From: Nicholas Fterniatis <nick.fterniatis@property.nsw.gov.au>
Sent: Monday, 29 November 2021 3:14 PM
To: Candice Pon
Cc: Andrew Watson; Michelle King
Subject: RE: Request for advice - Sirius Building - Removal and replacement of 2 trees on Gloucester Walk (SSD-10384-Mod-1)

The 2 sections below indicate the construction of the existing walls and footings at tree 50 and 51.

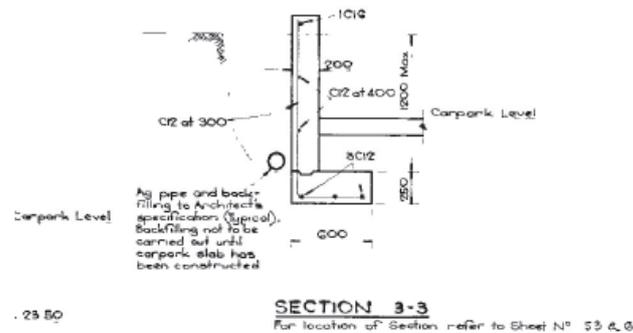
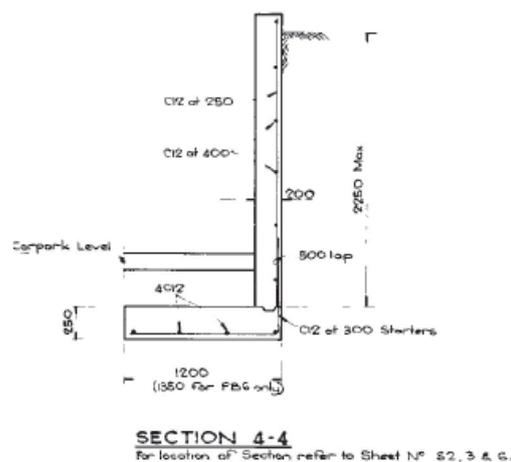
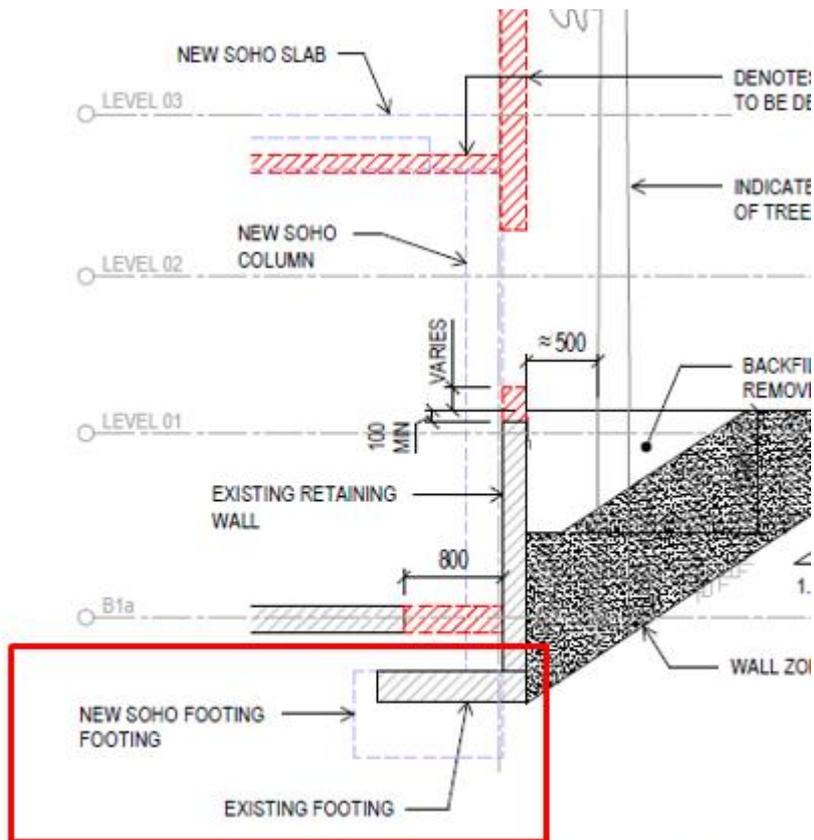
- The existing retaining walls are not compliant to current codes and cannot be certified
- The existing retaining walls are not compatible with the approved works (activation of Gloucester Walk)
- The retained material behind the walls needs to be removed
- The walls will need to be demolished and re-constructed
- Tree root damage to the retaining walls has been documented and is compromising the structural integrity of wall.

Essentially, the two trees are being supported by the surrounding walls, and when these walls are rebuilt (in order to be certified) the trees will not be able to be supported and will likely topple over as their root base (tree protection zone) will be greatly disturbed.
